Active  
Travel  
England

Your Ref: 2023/92448  
Our Ref: ATE/23/00496/OUT  
Date: 15 September 2023

## Active Travel England Planning Response Detailed Response to an Application for Planning Permission

**Site Address:** Former Cooper Bridge Water Treatment Works, Leeds Road,  
Huddersfield, WF14 0BT

SITE PLAN

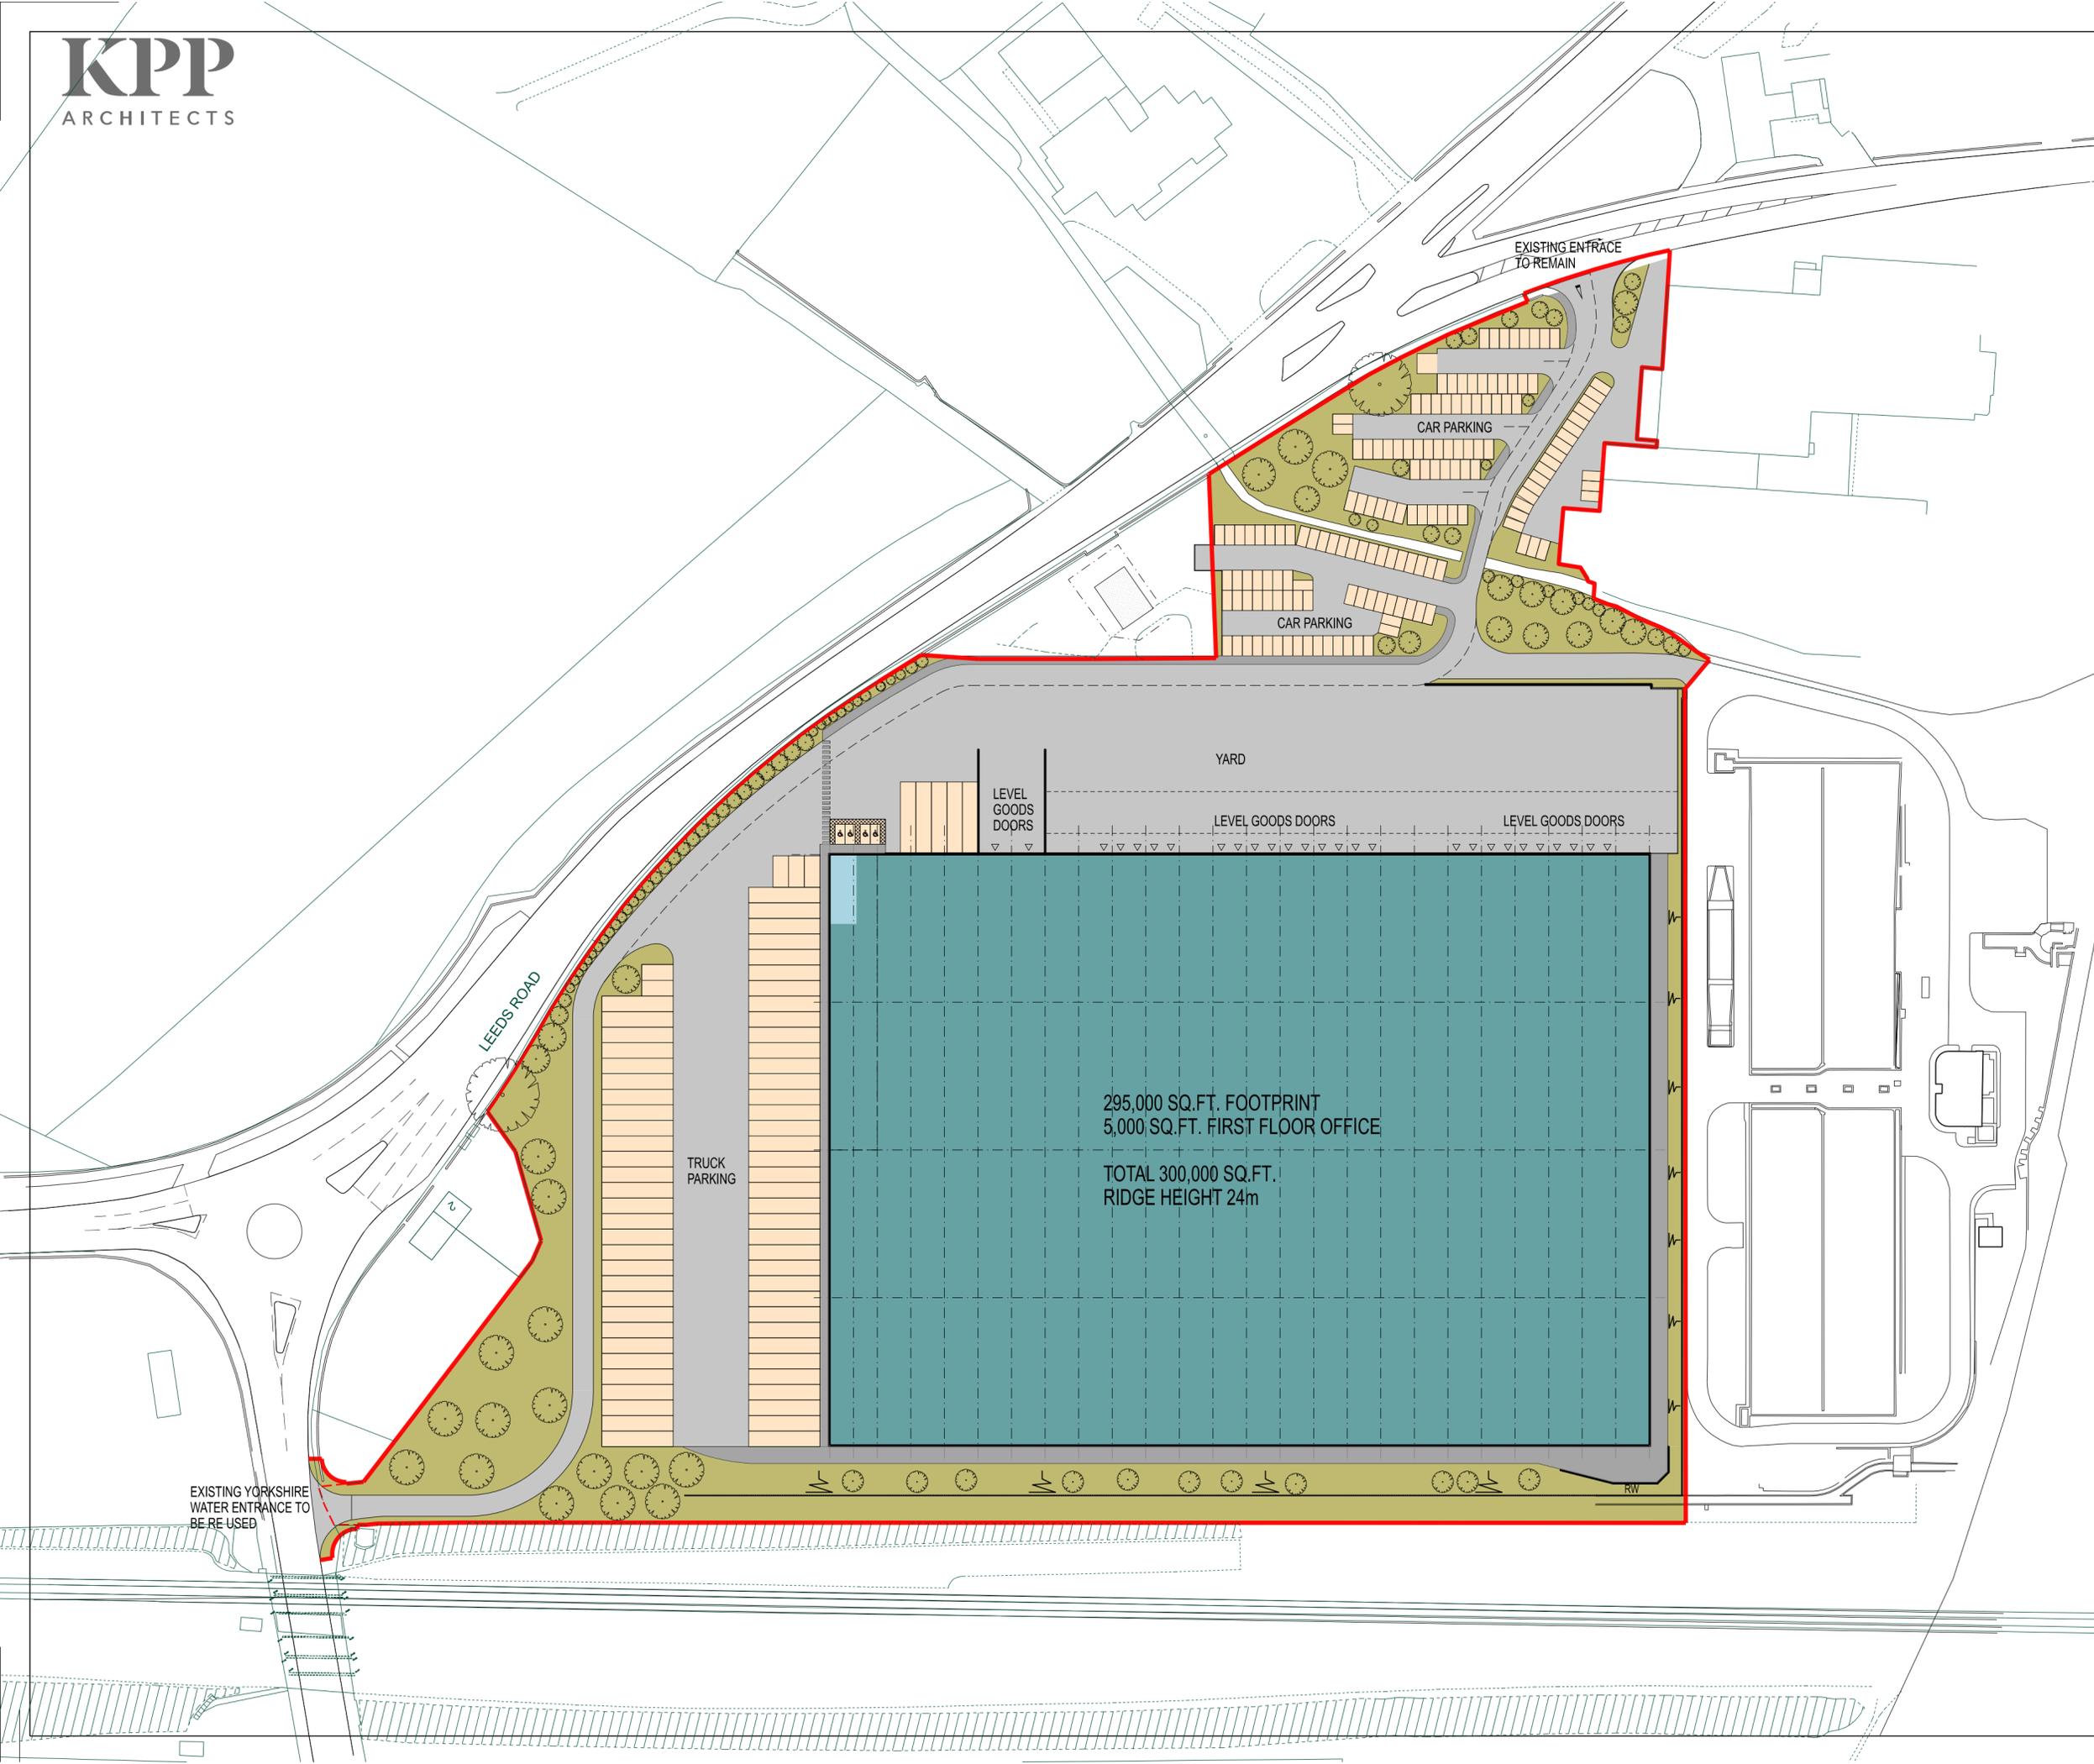
outline stage and would request that these are added to the Site Plan and Travel Plan to ensure they are carried through at reserved matters stage.

- The Travel Plan states that “covered and secure cycle parking will be provided within the site in accordance with Kirklees Council’s prevailing parking standards.” However, within Kirklees Council’s Highway Design Guide SPD (2018), paragraph 5.4 states that, “Kirklees Council has not set local parking standards for residential and non-residential development.” The development should therefore conform to LTN 1/20 standards detailed in Table 11-1, which advises a minimum of 1 secure and covered space per 500m<sup>2</sup> of floorspace. Based on a floorspace of 27,630m<sup>2</sup> this would result in a minimum of 56 spaces to be provided. The submitted Site Plan does not show any cycle parking and should be amended to show indicatively where this will be provided. A planning condition should also ensure full details of any structure and the type of stands to be used should be submitted at reserved matters. The Travel Plan should also be updated to confirm the number of spaces to be provided.

- In addition to the above, it should be made clear what facilities are available for staff who travel to the site using active travel modes. Section 11.7 of LTN 1/20 advises that to facilitate longer cycle commutes places of work should have changing rooms, lockers, showers and drying rooms. It should be made clear which of these facilities will be provided within the new development. If these are located within part of the existing site details should be provided of what these facilities are, their size, and where they are located in relation to cycle parking. As above, the Travel Plan should be updated to provide more details on these facilities.

- Amendments to the Site Plan and Travel Plan to provide details in principle of the provision of cycle parking (minimum 56 spaces) at the site and the provision of any staff facilities such as changing rooms, lockers, showers and drying rooms.
- Ensure the team/department leading on the A62 to Cooper Bridge Corridor Improvement Scheme have been consulted on the application.
